Subject: A/31/19/PL.

I am surprised the application is not being assessed pursuant to the granting of A/212/17/PL, which benefits from 2 Extant Plots (8 and 9) and which defines the Extent of Use and The First Schedule, and come under reserved matters. A/87/18/PL is one large plot and half of A/176/17/PL, both of which were refused by Arun, and A/176/17/PL was also dismissed at appeal. The lower part of A/87/18/PL is covered by A/212/17/CLP and A/212/17/CLP covers both A/31/19/PL and the remaining extant plot which is material in this matter.

A/31/19/PL proposes one large dwelling on Plot 9 which is a similar property to that on A/87/18/PL but on a smaller plot. A/87/18/PL was refused under policies D DM1, OSR DM1 and HD5.

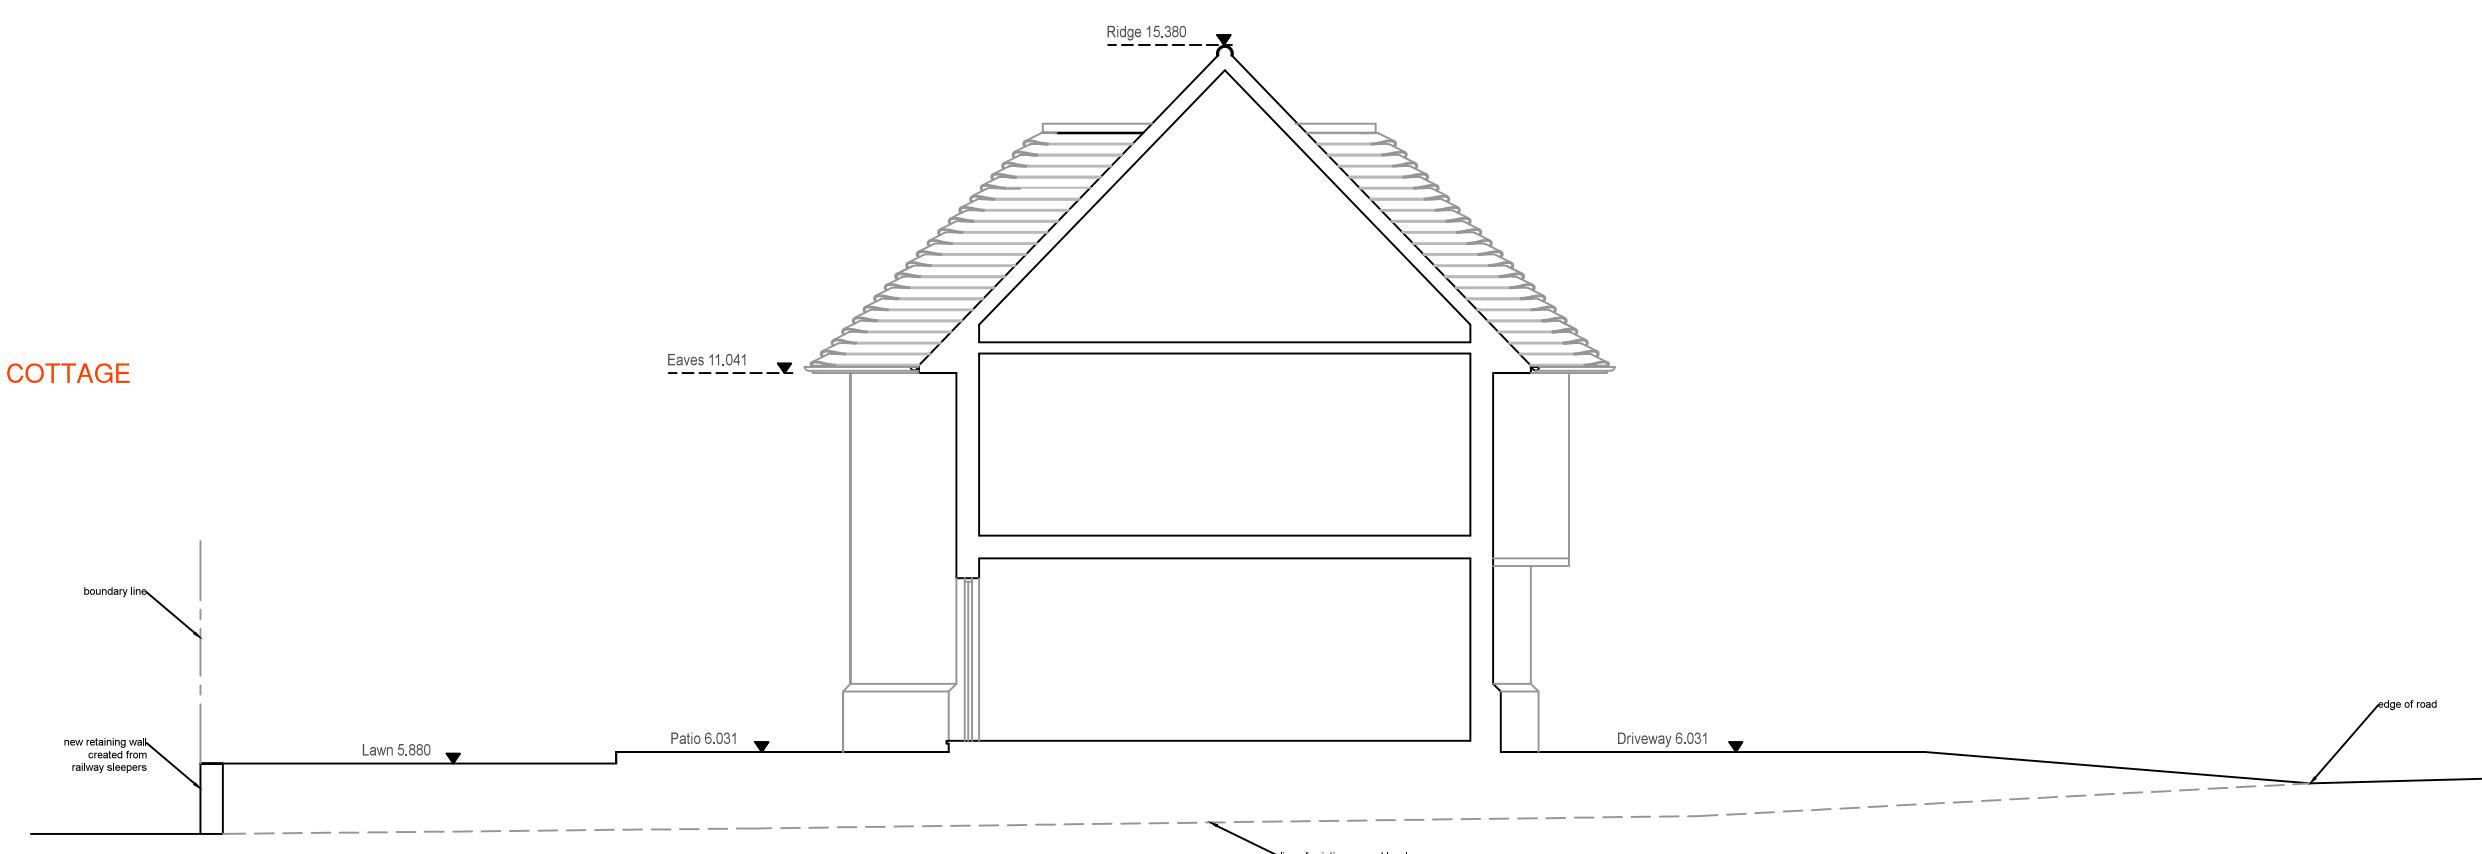
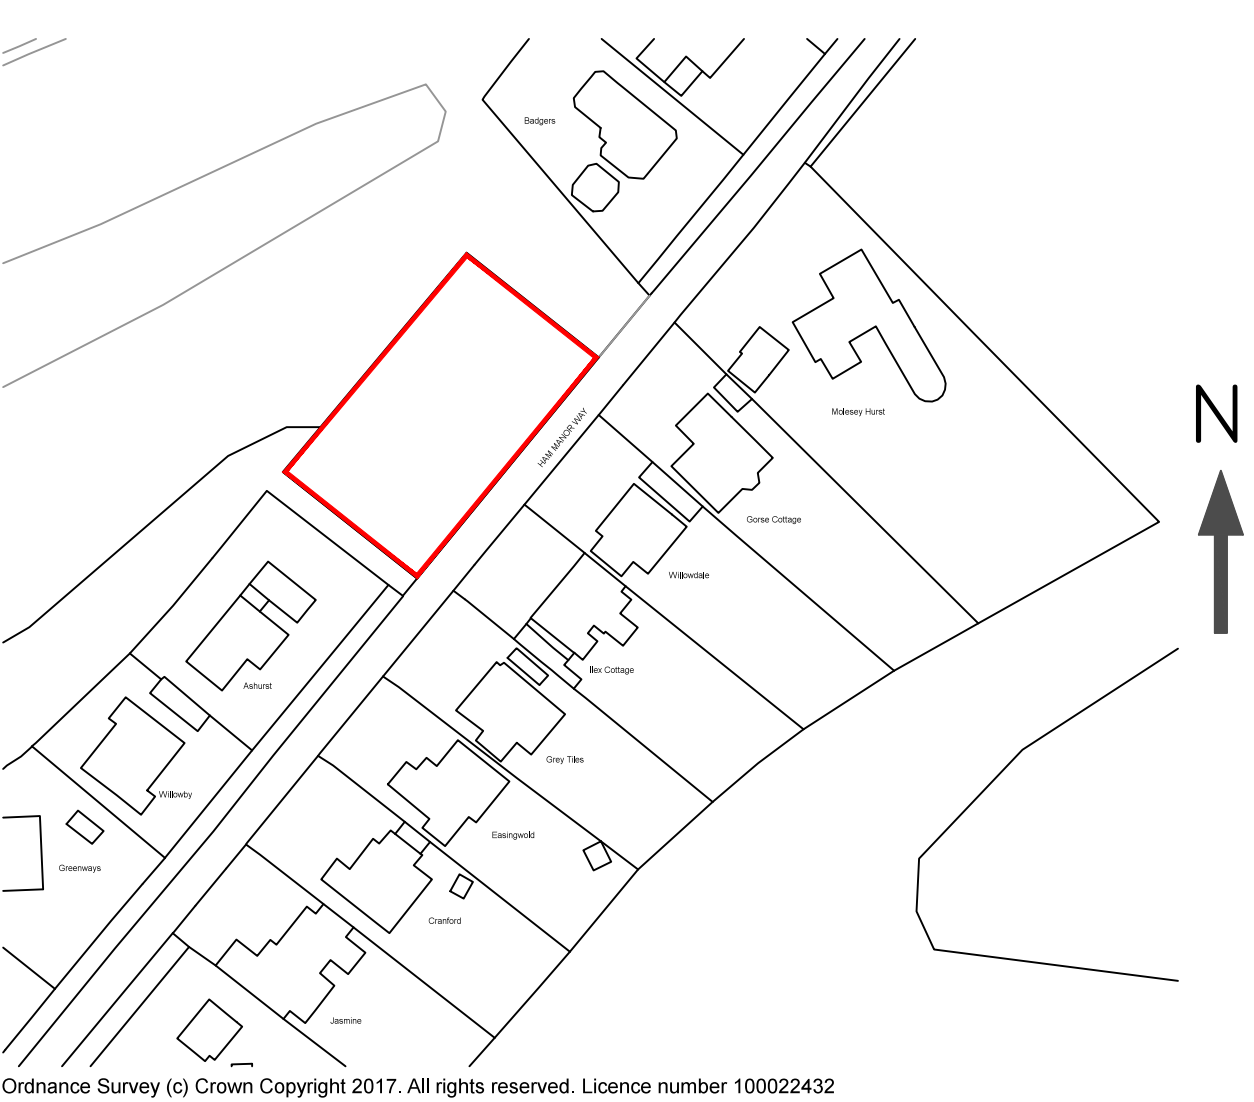
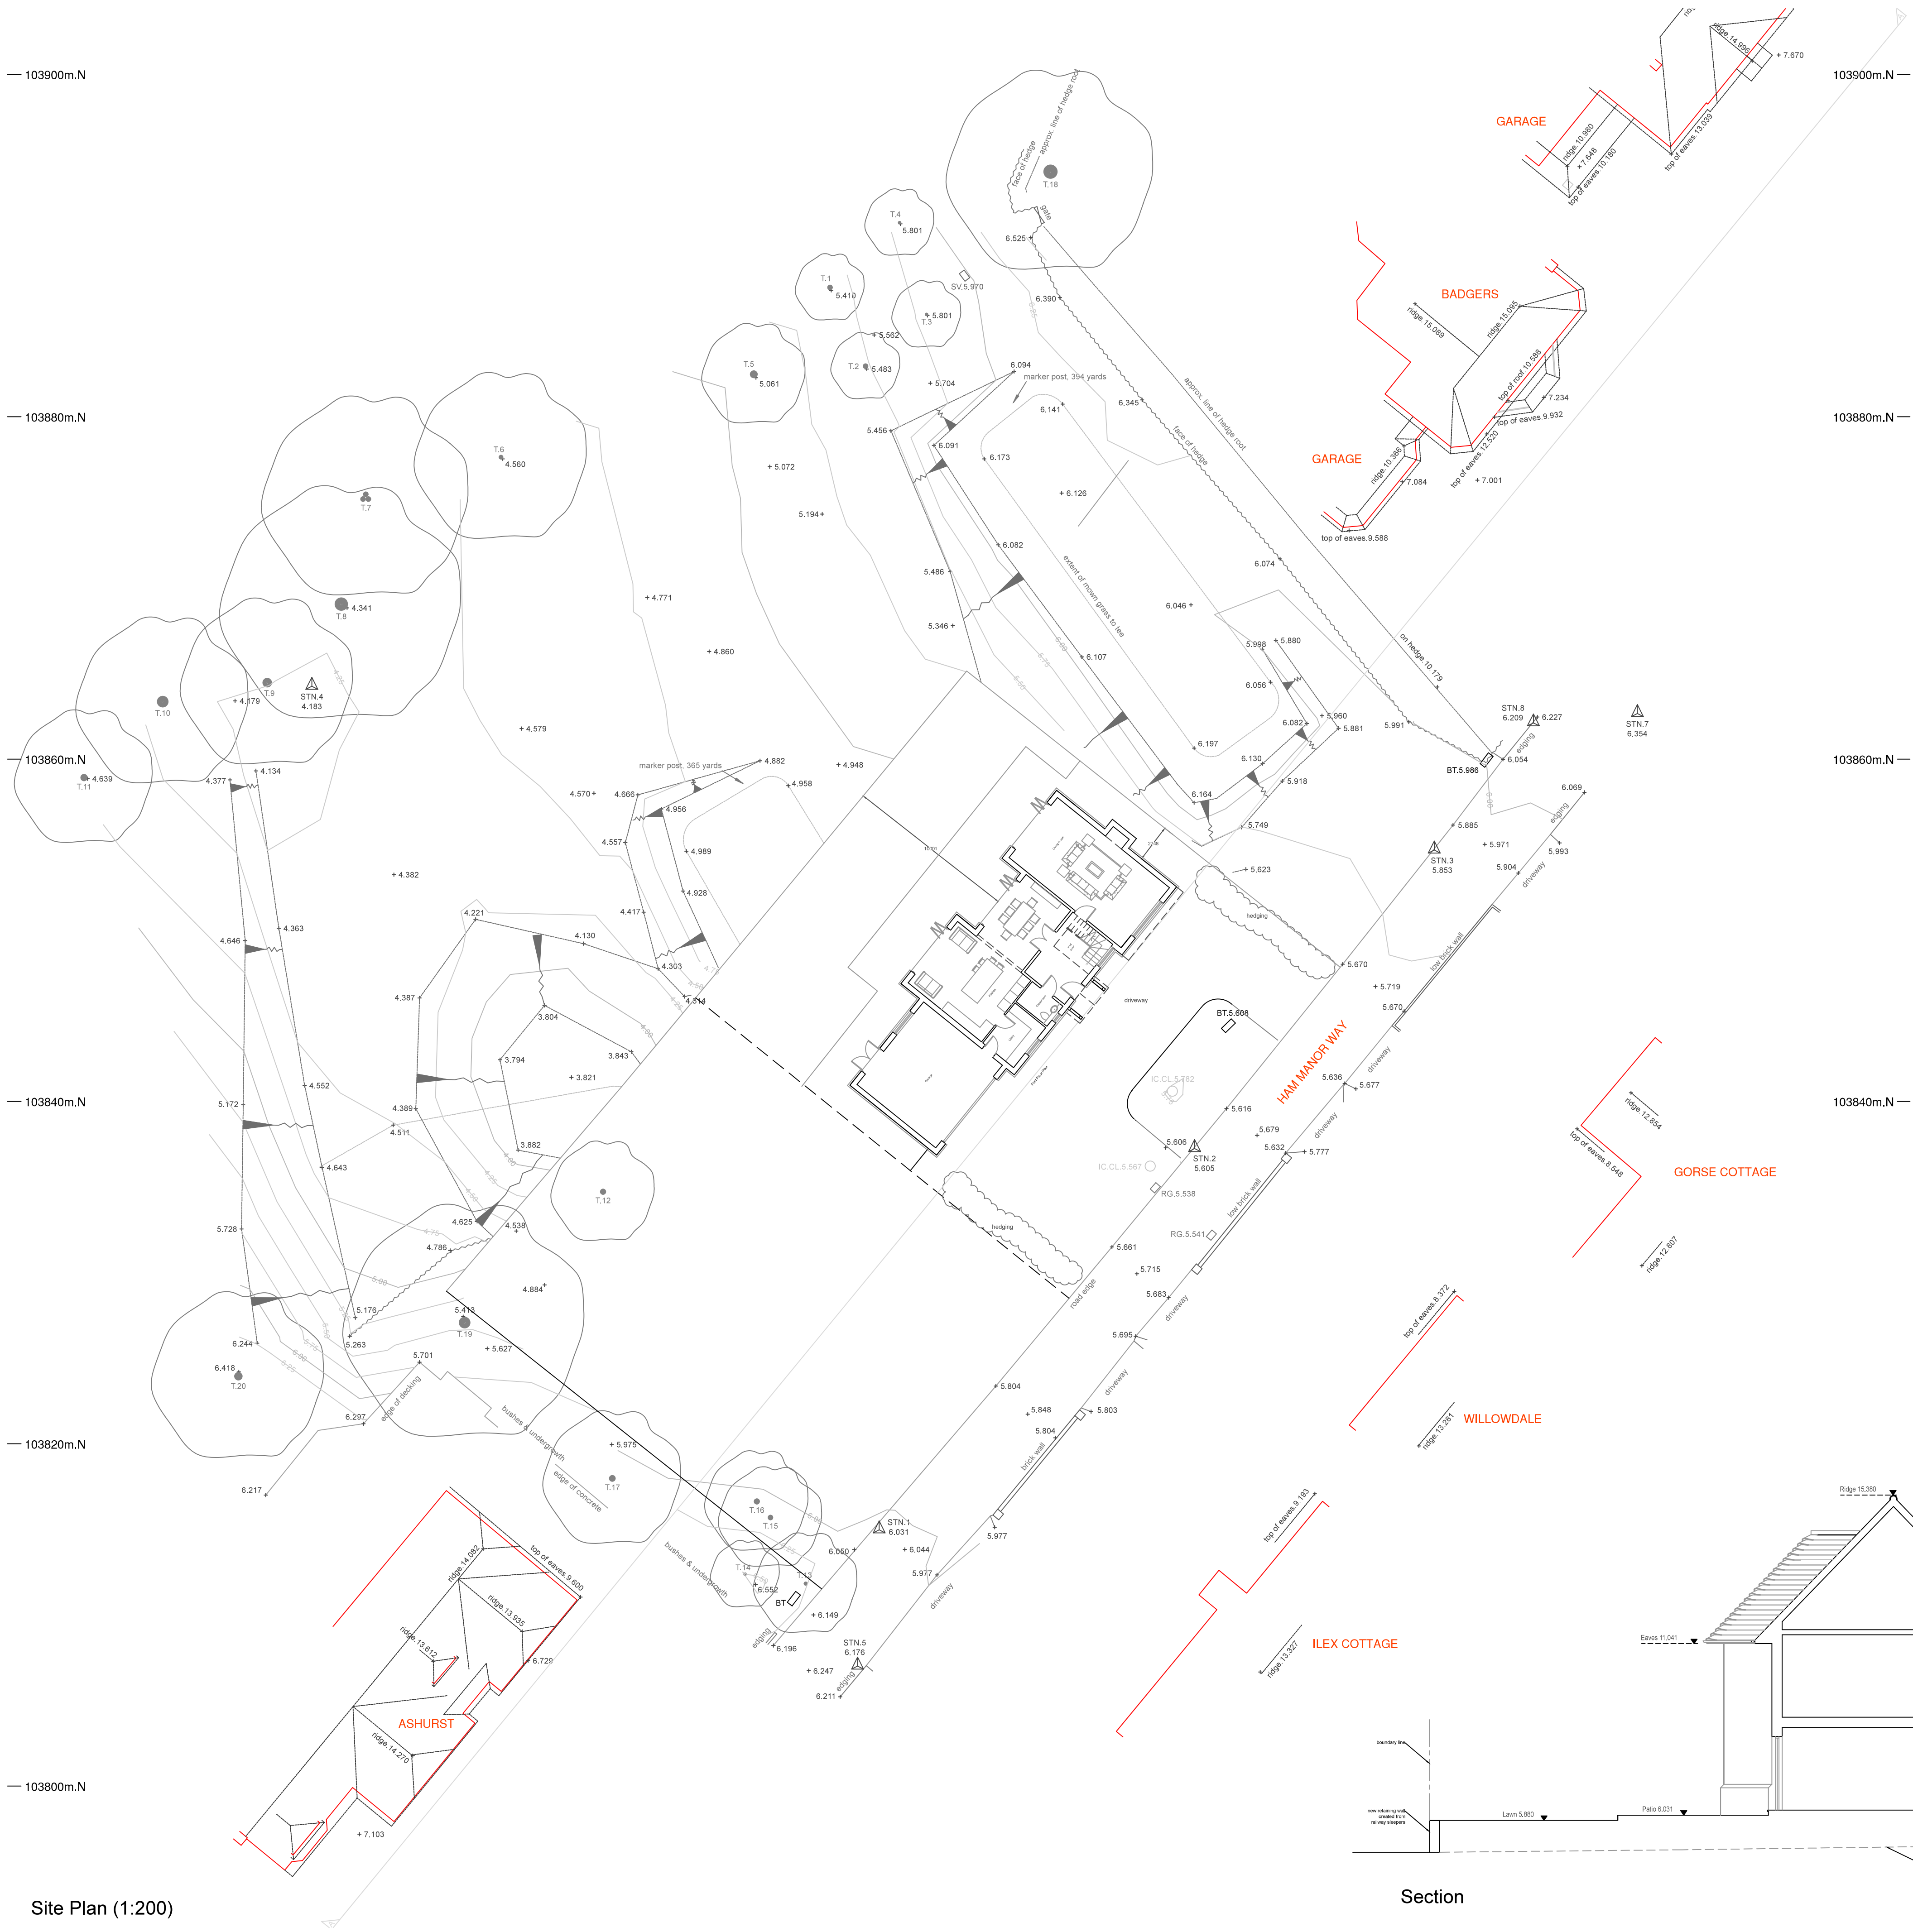
The Engineer (Drainage & Coastal) has commented on drainage and I would add that there is a road drain beside the proposed development and the associated soak away will be within the proposed site. They obviously will no doubt be protected in any development but the road at this point can flood and any development or increase in the land height as proposed could worsen drainage and flooding.

The proposed dwelling sits much closer to the road than other properties and therefore has a greater impact. It also appears to be in front of the established build line. It should also be noted that the Inspector refers to properties being a comfortable distance from the road.
